From: Richard Martin
Sent: 19 October 2017 14:43
To: Zac Denton
Cc: Juan Baeza
Subject: FW: R/1/17/T
Attachments: BROOKENBEE CLOSE.R.1.17.T.pdf; COWDRAY DRIVE.R.1.17.T.pdf;
HUTCHISON.SUMMERLEY.FOXES.R.1.17.T.pdf; WATERSMEAD DRIVE.R.1.17.T.pdf

Bernie has provided approval for as much as he can, as anticipated some further work/specific details are required from the applicant. Hopefully this is clearly set out in the attached.

WATERSMEAD DRIVE

BROOKEN BEE

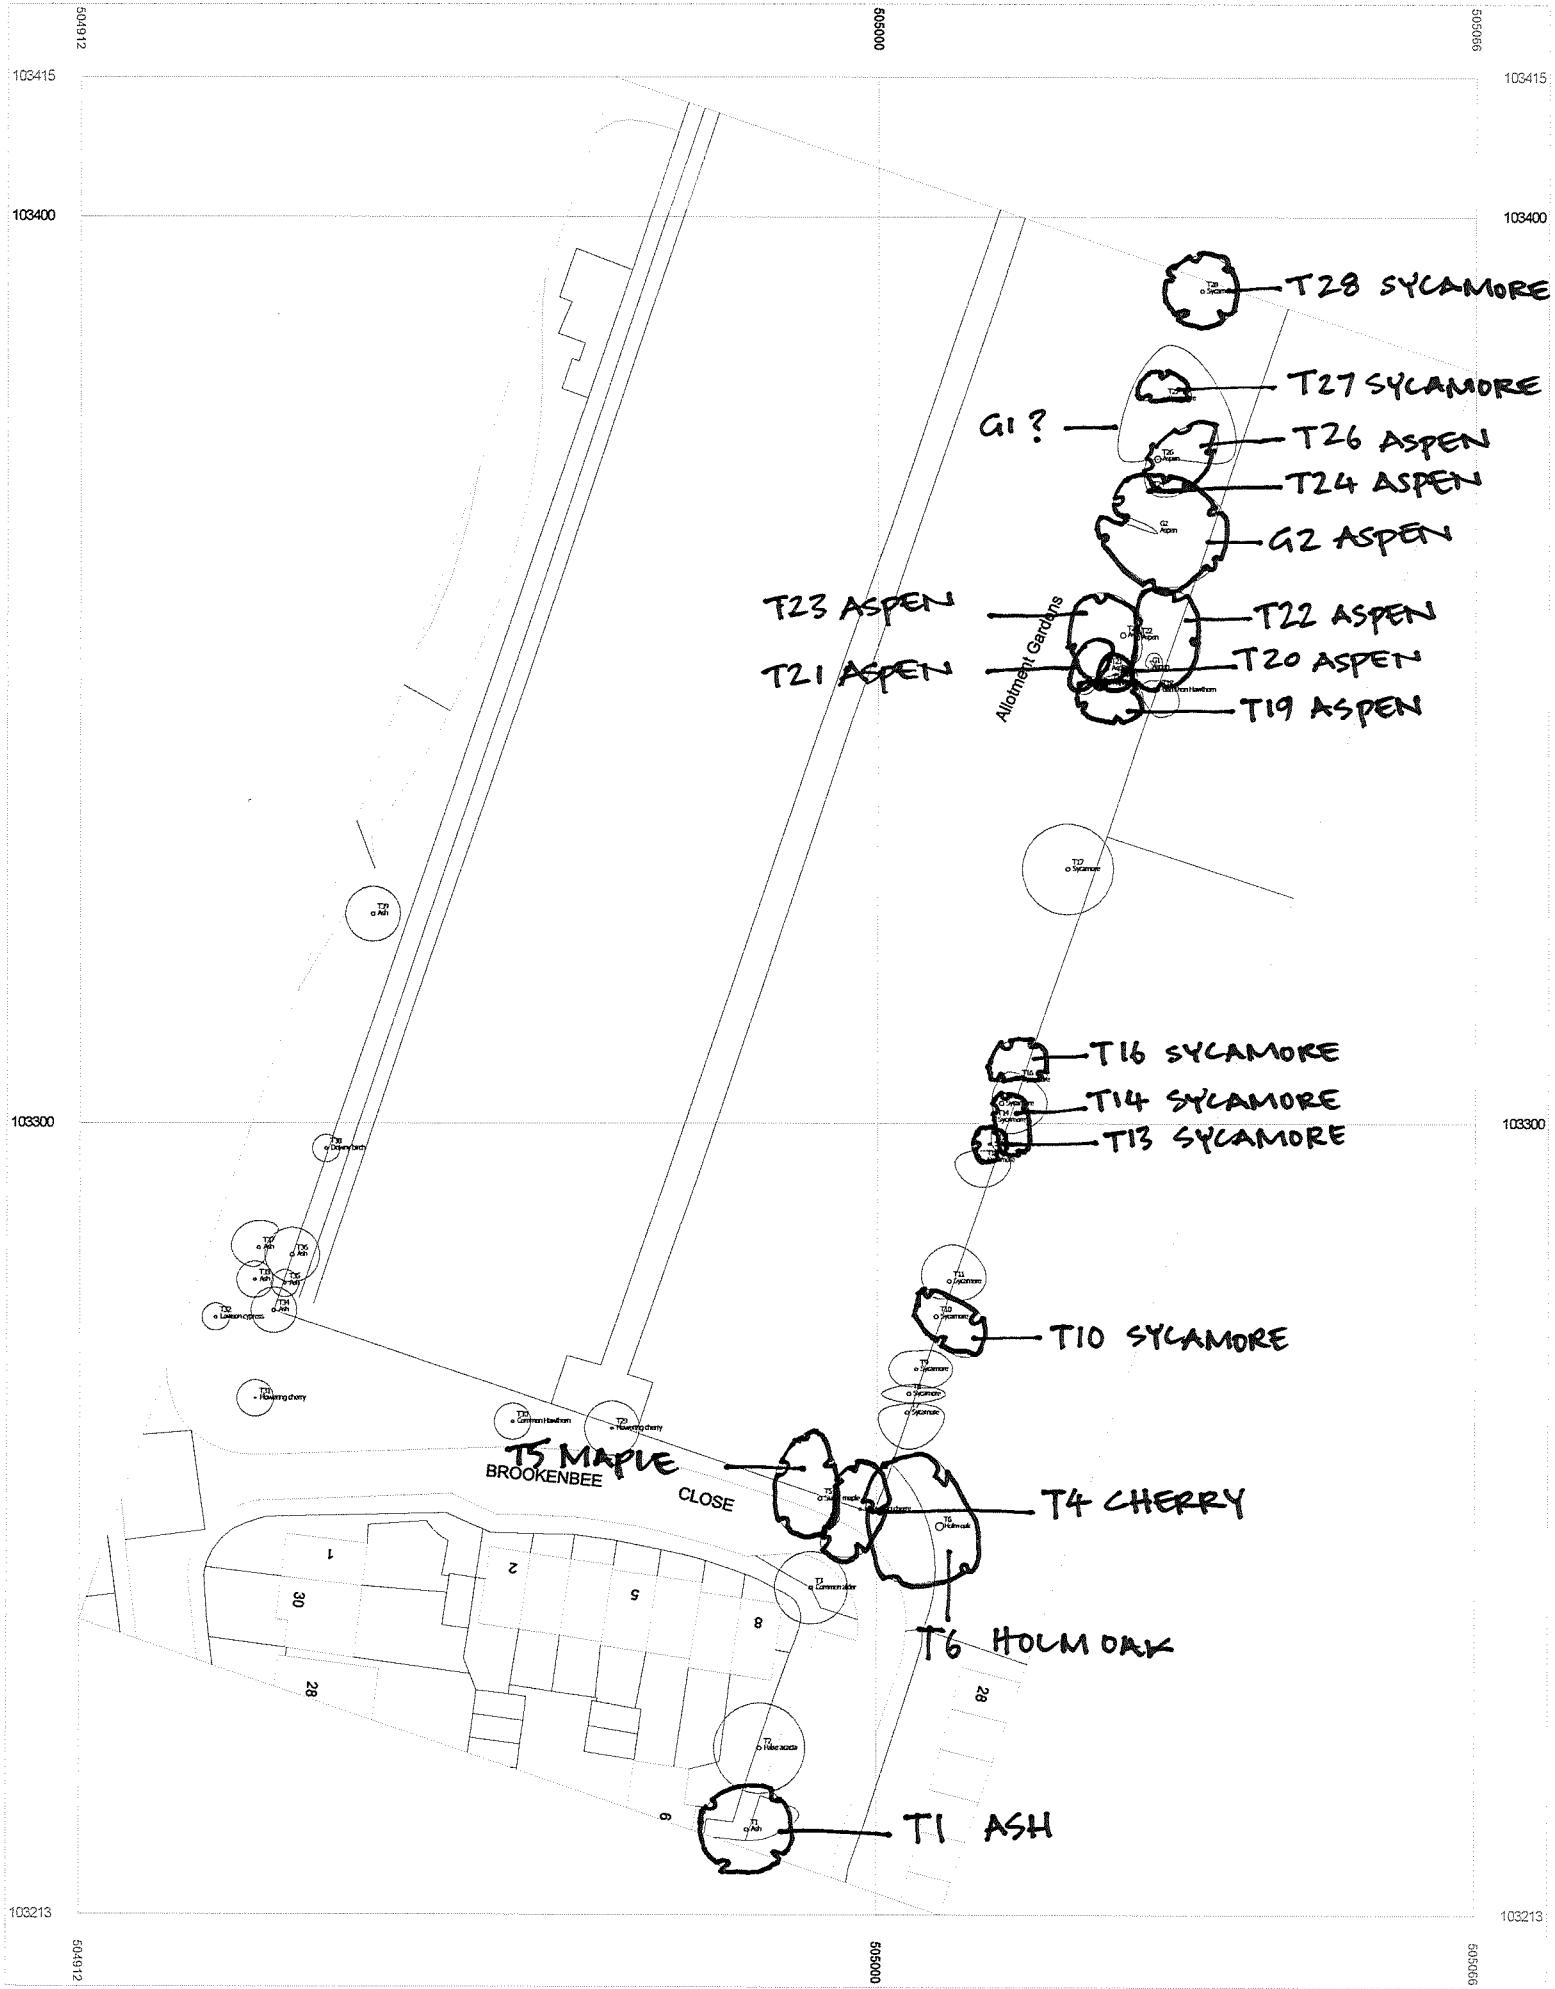
No.	Species	Work Applied For	Works Approved	Works Refused	Advised Works For Re-Submission
T1	Ash	Crown lift to 5m above ground over road	-	5m is excessive and would make large wounds contrary to BS3998 recommendations	Crown lift to a lesser degree of 3m maximum with no cuts over 100mm diameter being formed and seek to reduce the next tier of laterals above this to give the tree a more upswept appearance
T4	Cherry	Crown lift to 5m above ground over road	Crown lift to achieve a 5m ground clearance on the road side of the tree ONLY and make cuts no larger than 100mm diameter.	-	-
T5	Silver Maple	Crown lift to 5m above ground over road	Crown lift to achieve a 5m ground clearance on the road side of the tree ONLY and make cuts no larger than 100mm diameter.	-	-
T6	Holm Oak	Fell	Fell to ground level and then have the stump ground out and a new tree of the same species is to be planted at the same place. This is to be of Heavy Standard Nursery Stock proportions (12-14cm girth & 3m to 4m overall height) supported on a 'short stake' system with appropriate securing ties and pads. It is to be planted within 12 months of the removal.	-	-

T10	Sycamore	Sever or remove ivy	Do not require Council approval for this work	-	-
T13	Sycamore	Sever or remove ivy	Do not require Council approval for this work	-	-
T14	Sycamore	RB included limb at base Cut ivy	Remove branch – included limb at base Do not require Council approval to cut ivy	-	-
T16	Sycamore	Reduce faulted limbs/stems remove included stem at base	-	Reduce faulted limbs/stems remove included stem at base - ?	It is presumed that they mean remove one stem and reduce the remaining stem but no dimensions have been provided for the reduction works – these will be required + confirmation of exactly what they mean.
T19	Aspen	RB Fell southern stem	Remove Branch- fell southern stem	-	-
T20	Aspen	Fell	Agreed – no replacement will be required in this instance	-	-
T21	Aspen	Cut ivy	Do not require Council approval to cut ivy	-	-
T22	Aspen	Reduce faulted limbs/stems reduce included eastern stem to 5m Sever/remove ivy	Do not require Council approval for sever/remove ivy	Reduce faulted limbs/stems reduce included eastern stem to 5m	Reduce by how much – dimension required? Is reduction of eastern stem 5m in from tip or 5m out from trunk?

T23	Aspen	Reduce crowns to boundary Sever/remove ivy	Do not require Council approval for sever/remove ivy	Reduce crowns to boundary	For consistency they will need to specify how much back the tips or out from the trunks? Reduce by how much – dimensions required?
T24	Aspen	Reduce faulted limbs/stems Remove north east limb back to origin/union Cut ivy	Remove north east limb back to origin/union Do not require Council approval to cut ivy	Reduce faulted limbs/stems	Need clarification of what exactly this means – are there 5 branches or is it one limb cut back by 4m to 5m ?
T26	Aspen	CR5 : From trunk 4 to 5m	-	CR5 : From trunk 4 to 5m	-
T27	Sycamore	Sever or remove ivy	Do not require Council approval for this work	-	-
T28	Sycamore	Fell	Agreed – no replacement will be required in this instance	-	-

PARKLAND HUTCHINSON SUMMERLY FOXES, - NORTH

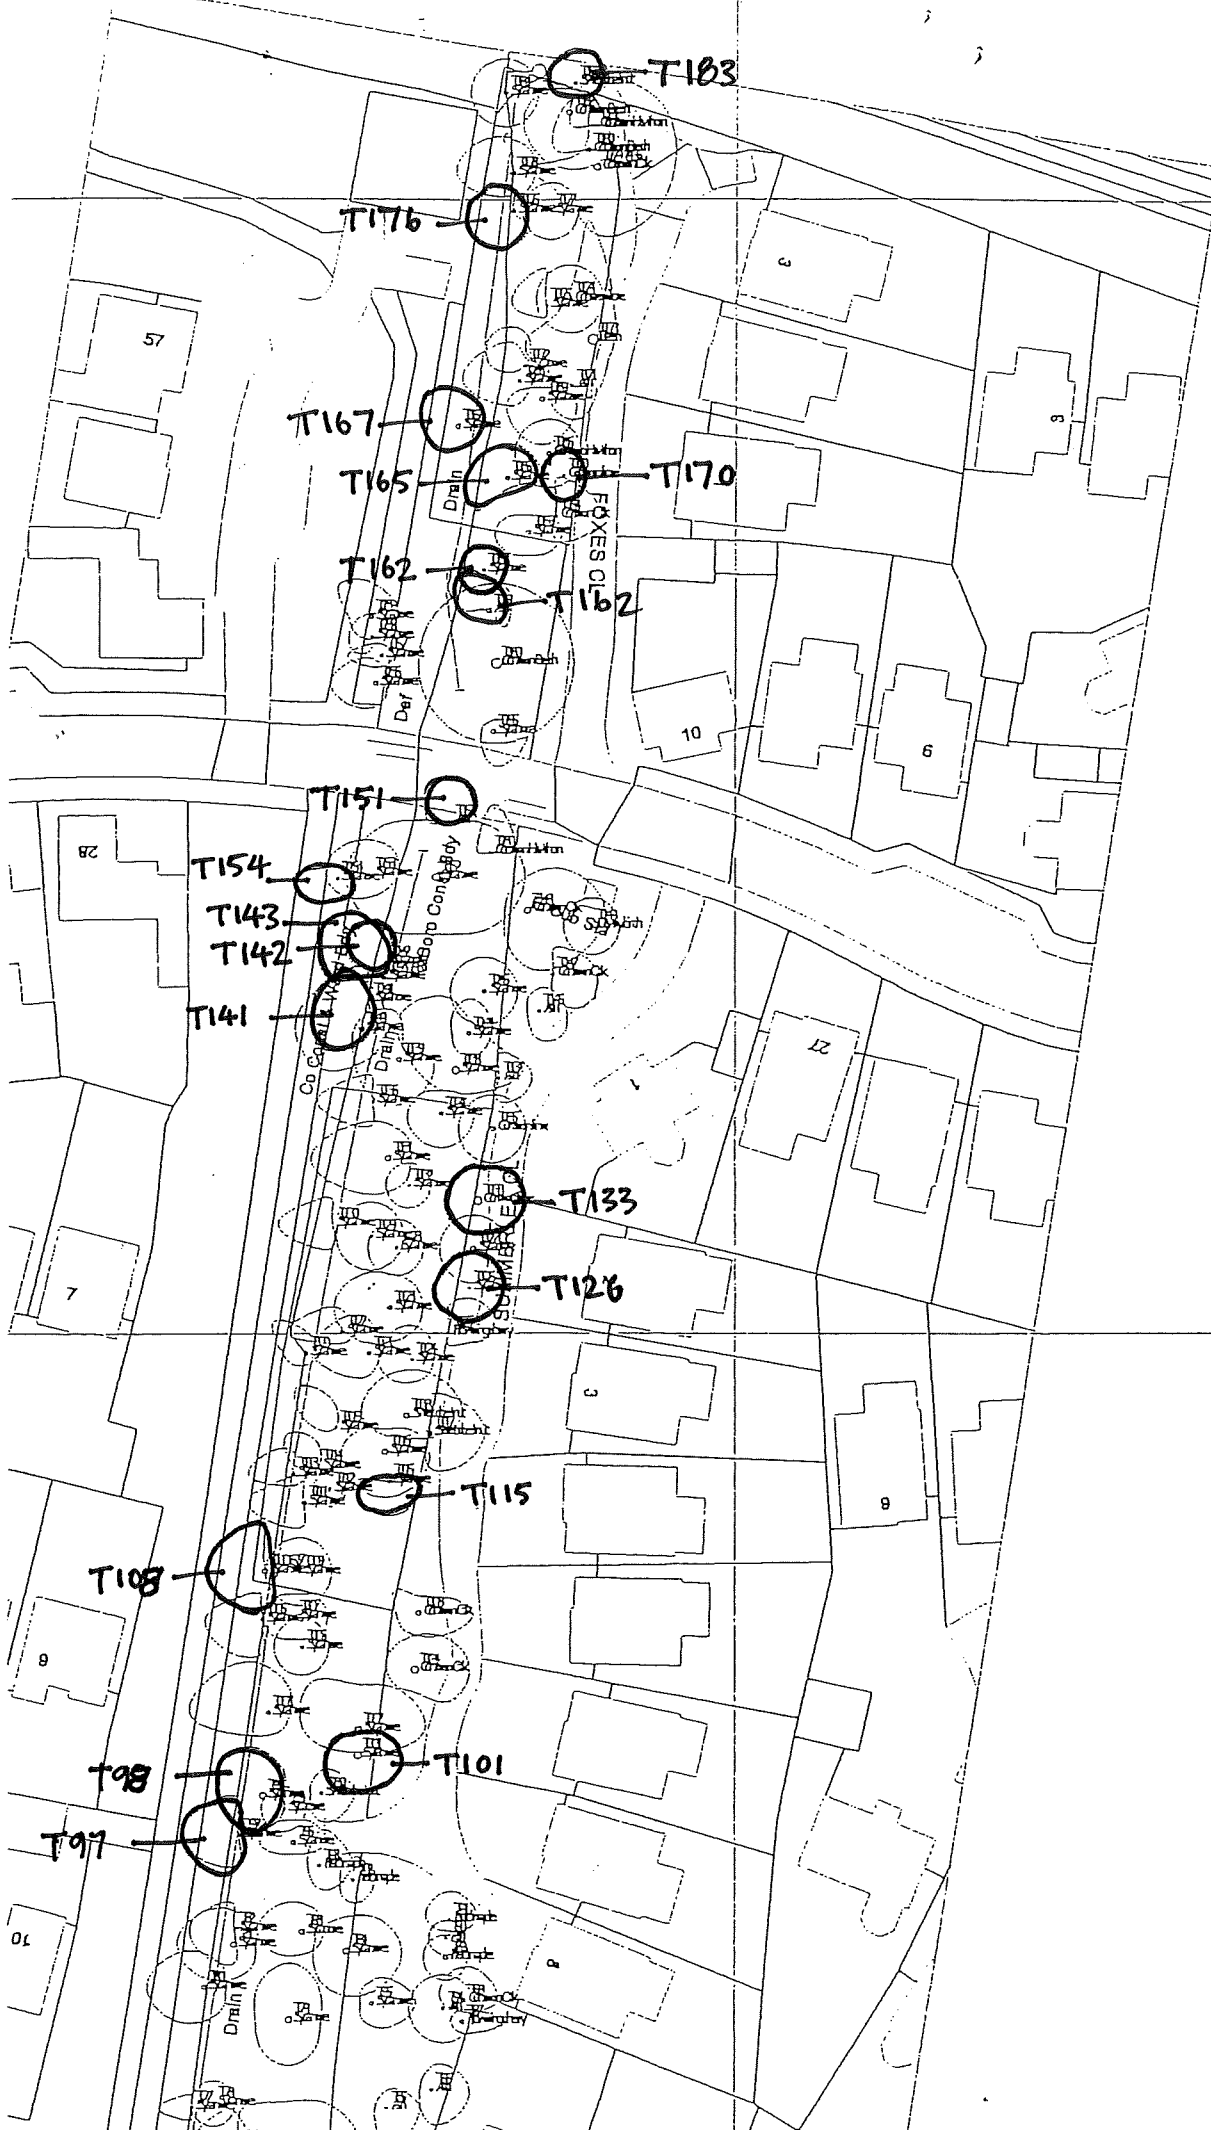
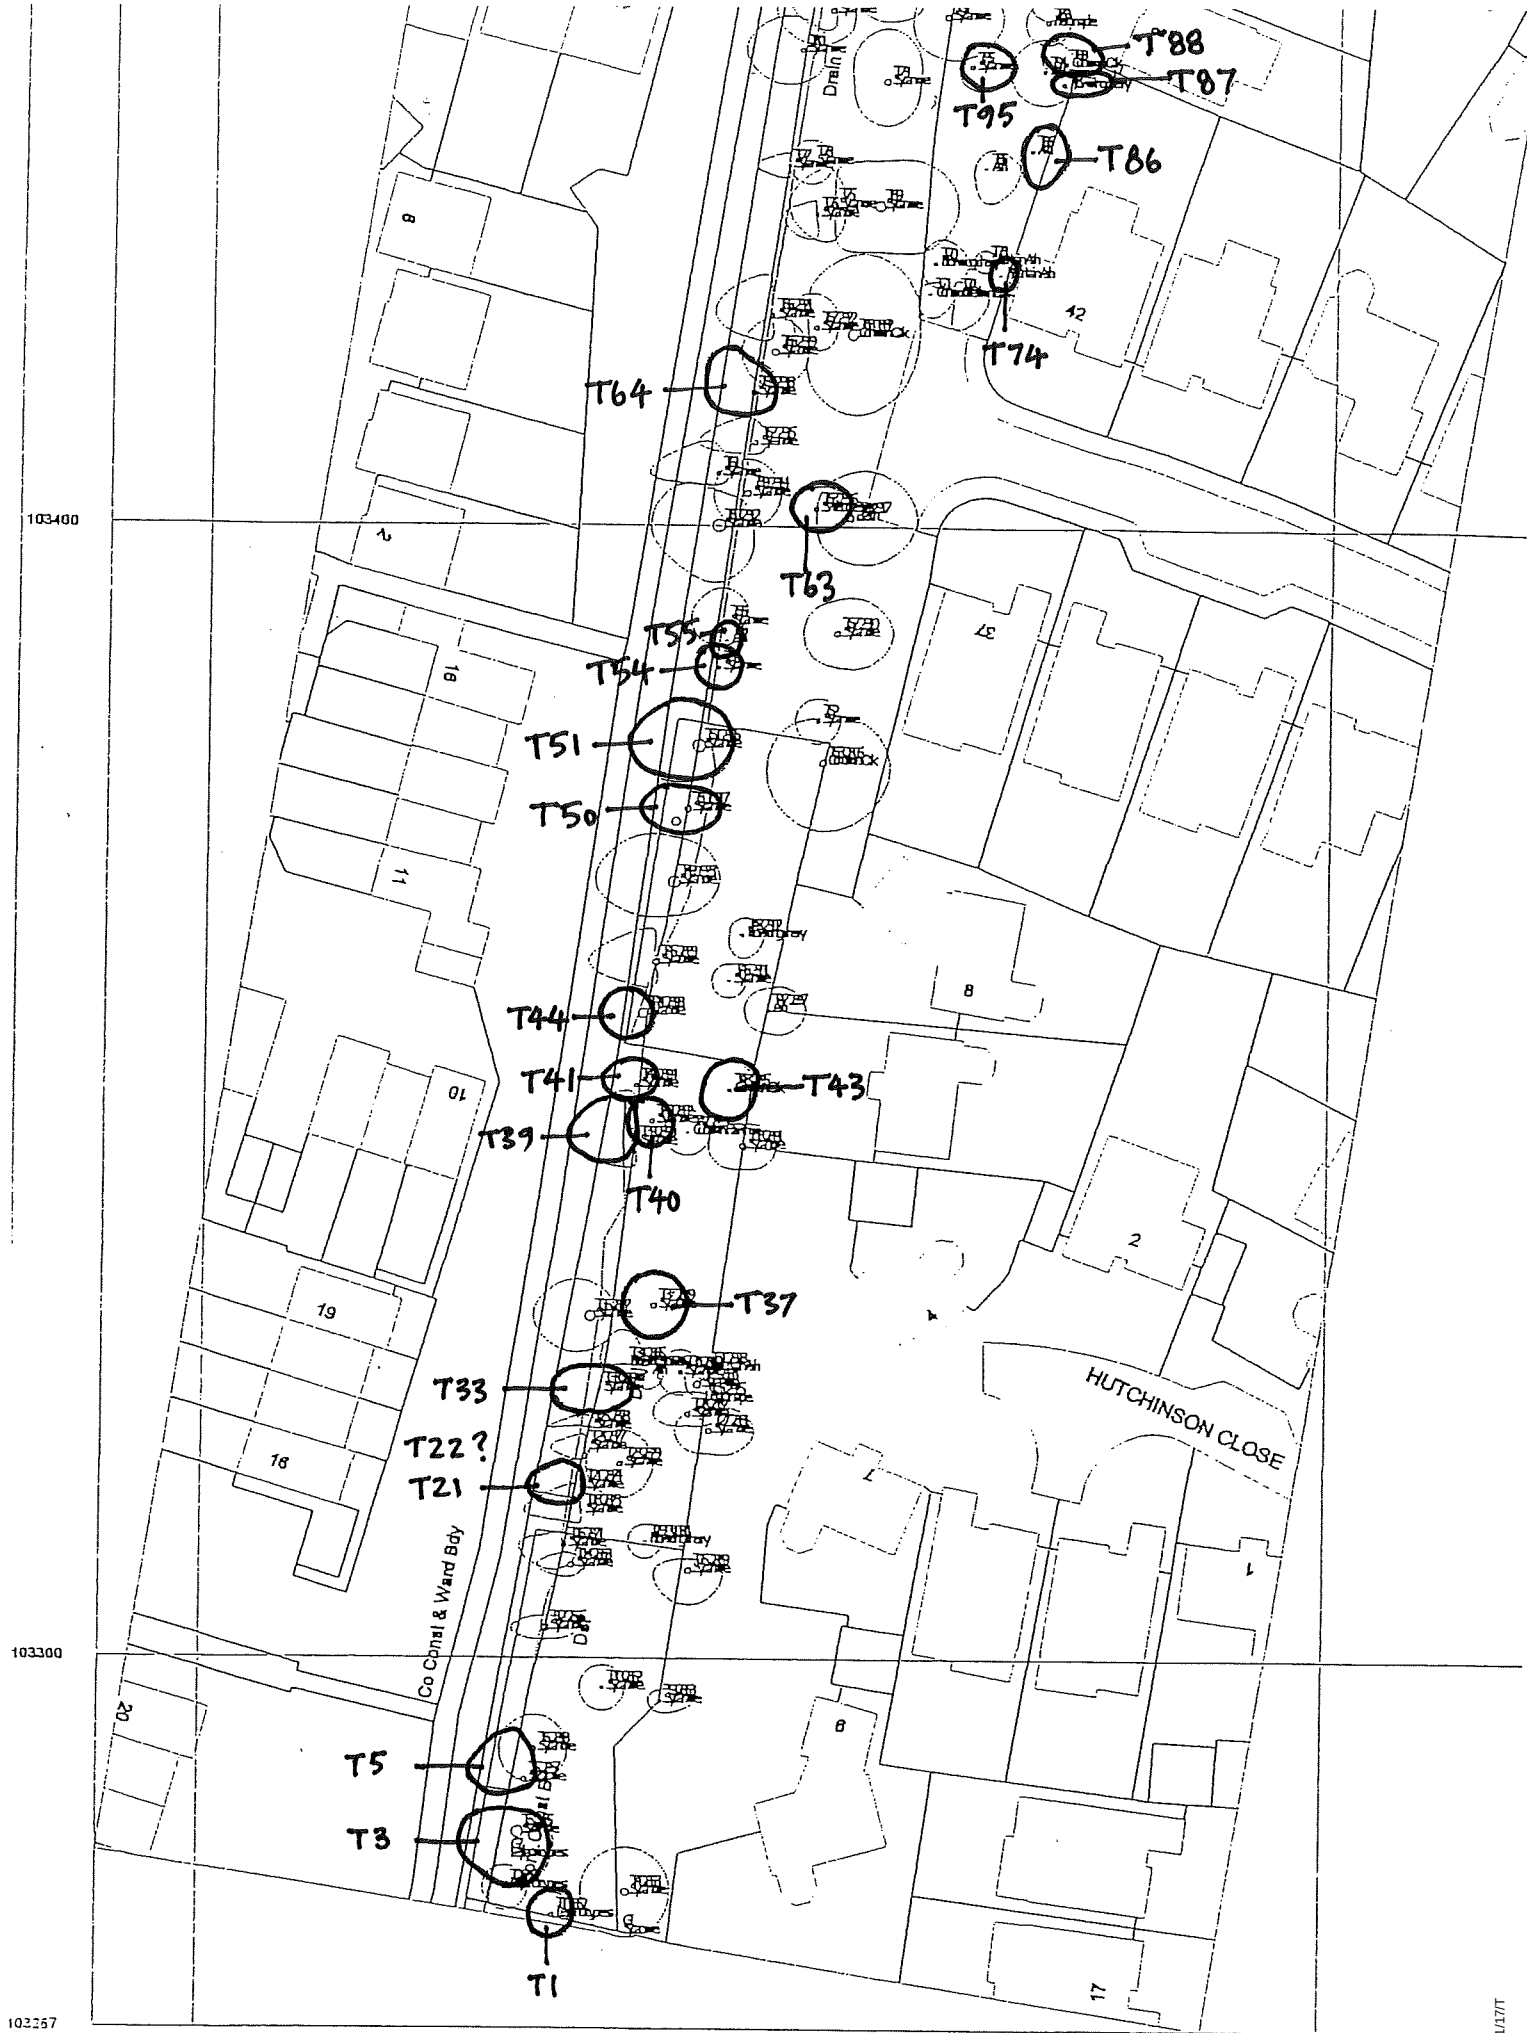
No.	Species	Work Applied For	Works Approved	Works Refused	Advised Works For Re-Submission
T1	Leyland Cypress	Reduce lateral limbs by 1.5m towards adjacent property	Reduce lateral limbs by 1.5m towards adjacent property	-	-
T3	Sycamore	RB remove lowest branch west side originating at 4m	Remove lowest branch west side originating at 4m	-	-
T5	Sycamore	Reduce lateral limbs to west by 2m RH From ground level of southern stem by 4m to suitable growth point	Reduce lateral limbs to west by 2m	Reduce height from ground level of southern stem by 4m to suitable growth point	Do not understand the specification - needs clarification?
T21	Sycamore	CI	Cut ivy – does not need ADC approval	-	-
T22	Sycamore	CI	Cut ivy – does not need ADC approval	-	-
T33	Sycamore	Ivy Sever/remove ivy	Ivy Sever/remove ivy– does not need ADC approval	-	-
T37	Sycamore	Reduce crown(s) reduce height by 2m to 3m	Reduce crown(s) reduce height by 2m to 3m	-	-

T40	Sycamore	Ivy Sever/remove ivy	Ivy Sever/remove ivy– does not need ADC approval	-	-
T41	Sycamore	Ivy Sever/remove ivy	Ivy Sever/remove ivy– does not need ADC approval	-	-
T43	Oak	Ivy Sever/remove ivy	Ivy Sever/remove ivy– does not need ADC approval	-	-
T44	Sycamore	RH From ground level reduce west stem 3m to 4m east by 2m	-	RH From ground level reduce west stem 3m to 4m east by 2m	Do not understand the specification - needs clarification?
T46	Sycamore	Ivy Sever/remove ivy	Ivy Sever/remove ivy– does not need ADC approval	-	-
T49	Sycamore	Ivy Sever/remove ivy DW	Ivy Sever/remove ivy– does not need ADC approval Deadwood – does not need ADC approval	-	-
T50	Sycamore	Ivy Sever/remove ivy	Ivy Sever/remove ivy– does not need ADC approval	-	-
T51	Sycamore	End weight reduction reduce western stem by 2m	End weight reduction reduce western stem by 2m	-	-
T54	Sycamore	RB with squirrel damage	Remove branch with squirrel damage	-	-

T55	Ash	Fell to ground level	Fell to ground level	-	-
T57	Sycamore	Ivy Sever/remove ivy	Ivy Sever/remove ivy– does not need ADC approval	-	-
T59	Sycamore	Ivy Sever/remove ivy	Ivy Sever/remove ivy– does not need ADC approval	-	-
T62	Sycamore	Ivy Sever/remove ivy	Ivy Sever/remove ivy– does not need ADC approval	-	-
T63	Sweet Chestnut	Reduce faulted limbs/stems reduce leaving in decayed section as habitat	Reduce faulted limbs/stems reduce leaving in decayed section as habitat	-	-
T64	Sycamore	Ivy Sever/remove ivy Reduce faulted limbs/stems remove northern ingrown stem	Ivy Sever/remove ivy– does not need ADC approval Reduce faulted limbs/stems remove northern ingrown stem	-	-

T126	Sycamore	Fell	Fell	-	-
T130	Sycamore	Ivy Sever/remove ivy	Ivy Sever/remove ivy-- does not need ADC approval	-	-
T133	Lime	DW over road RBS	Deadwood - does not need ADC approval Remove basal suckers	-	-
T140	Sycamore	Ivy Sever/remove ivy	Ivy Sever/remove ivy-- does not need ADC approval	-	-
T141	Sycamore	RB crossing	-	Remove Branch crossing	Will need a better specification from a climbing inspection with photo's to show where they are in the tree and how many and which of each pairing is to be removed to justify actions
T142	Sycamore	Fell	Fell	-	-
T143	Sycamore	RB lowest stem	Remove Branch lowest stem	-	-
T151	Ash	CL 5 above ground	Crown Lift to 5m above ground	-	Advisory – why not remove altogether as this will be a repeat problem!
T154	Sycamore	Fell	Fell	-	-
T155	Sycamore	Ivy Sever/remove ivy	Ivy Sever/remove ivy-- does not need ADC approval	-	-
T156	Sycamore	Ivy Sever/remove ivy	Ivy Sever/remove ivy-- does not need ADC approval	-	-

T158	Sycamore	Ivy Sever/remove ivy	Ivy Sever/remove ivy-- does not need ADC approval	-	-
T159	Sycamore	Ivy Sever/remove ivy	Ivy Sever/remove ivy-- does not need ADC approval	-	-
T160	Beech	CC? DW over road	Deadwood - does not need ADC approval	Crossing branches	Will need a better specification from a climbing inspection with photo's to show where they are in the tree and how many and which of each pairing is to be removed to justify actions
T161	Ash	RB remove squirrel damaged nw limb at 4m	RB remove squirrel damaged nw limb at 4m	-	-
T162	Sycamore	Ivy Sever/remove ivy	Ivy Sever/remove ivy-- does not need ADC approval	-	-
T165	Sycamore	Fell to ground level	Fell to ground level	-	-
T166	Hawthorn	Ivy Sever/remove ivy	Ivy Sever/remove ivy-- does not need ADC approval	-	-
T167	Sycamore	Fell to ground level	Fell to ground level	-	-
T168	Sycamore	Ivy Sever/remove ivy	Ivy Sever/remove ivy-- does not need ADC approval	-	-

T169	Sycamore	Ivy Sever/remove ivy	Ivy Sever/remove ivy-- does not need ADC approval	-	-
T170	Lime	Reduce faulted limbs/stems remove twisted stem	Reduce faulted limbs/stems remove twisted stem	-	-
